**Consultation Response from KC,
Lead Local Flood Authority**

2024/91996 Land at, Penistone Road, Fenay Bridge, Huddersfield, HD8 0AW

Date Responded: 13th August 2024

Condition 17 – Construction Phase Drainage Plan

Drawing No. 2078 - 004 Rev A

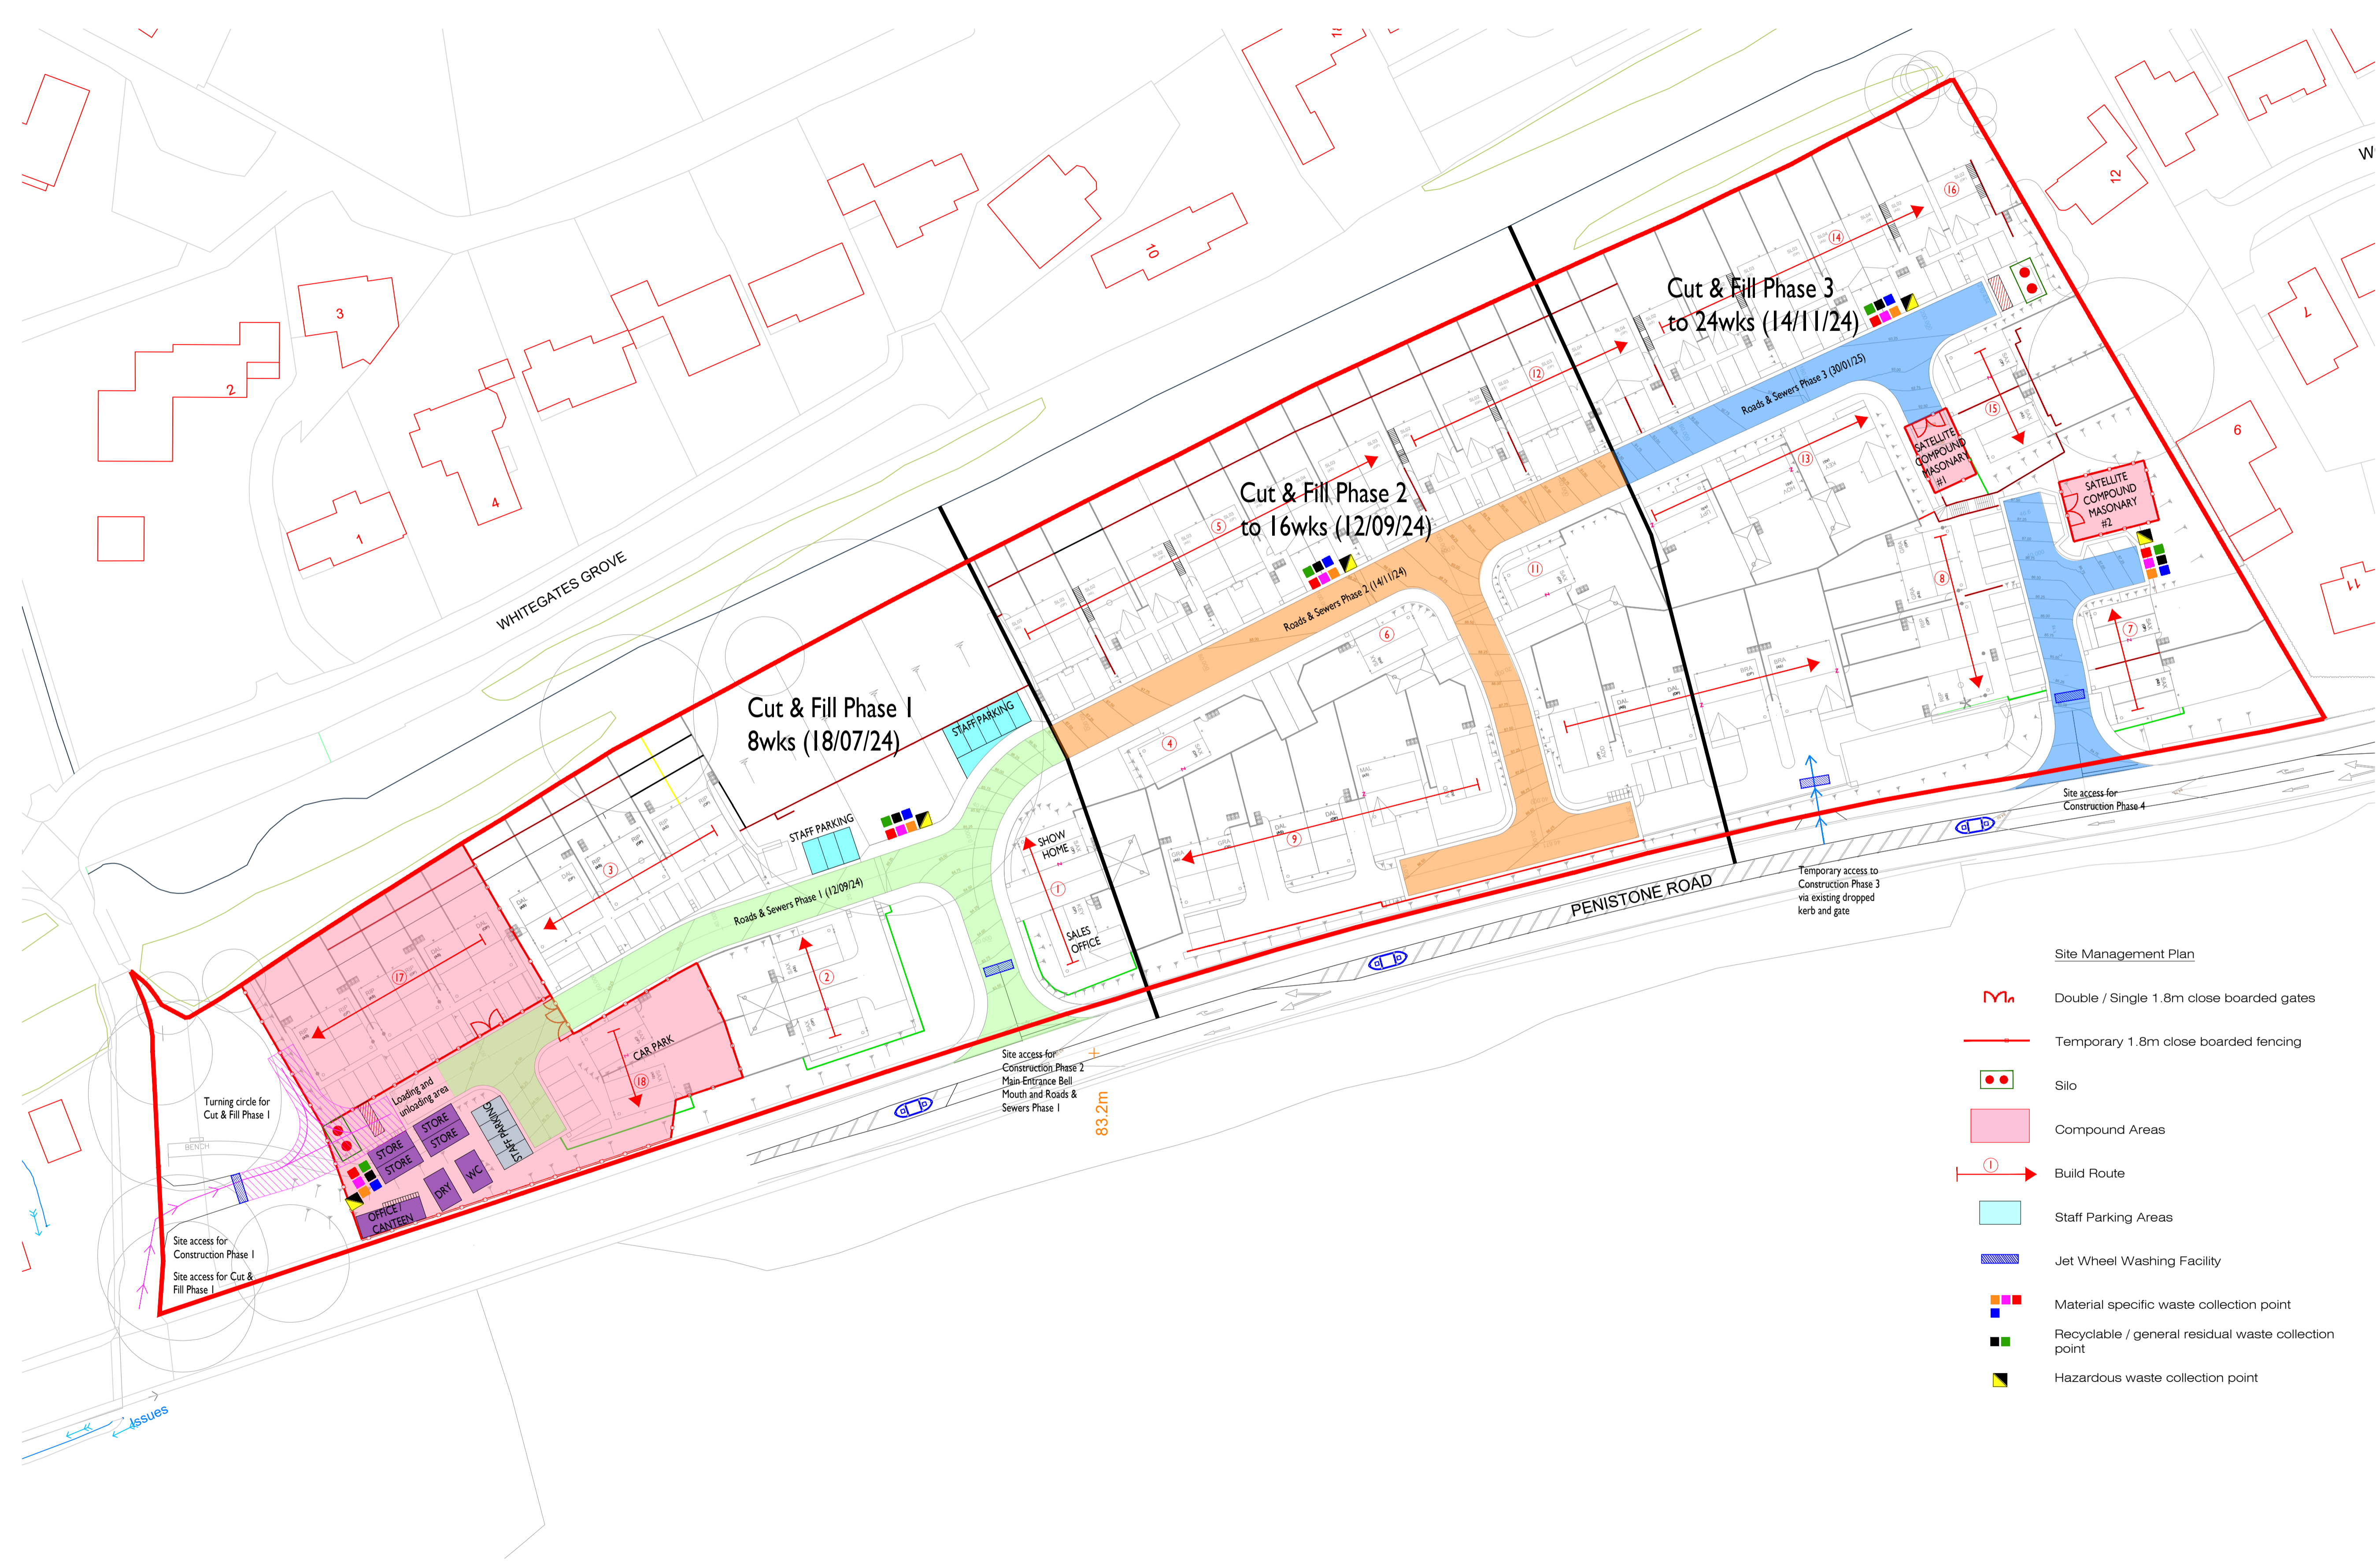
A method of collecting and separating silt has been produced on a plan for the initial phase. This needs to consider site access, spoil heaps and compound location and phases of the development programme as well as the contours (direction of run off).

We recommend that a 1 in 2 year 6-hour storm event is considered for retaining and treating water on site. This has to be demonstrated for the stages prior to the installation of the permanent attenuation tank.

Back up plans such as the use of tankers and flocculation need to be presented as part of the risk assessment and method statement.

Wheel washing and road sweeping needs to be considered for relevant phases, as does the protection of installed gullies and manhole from site debris for the 2nd phase.
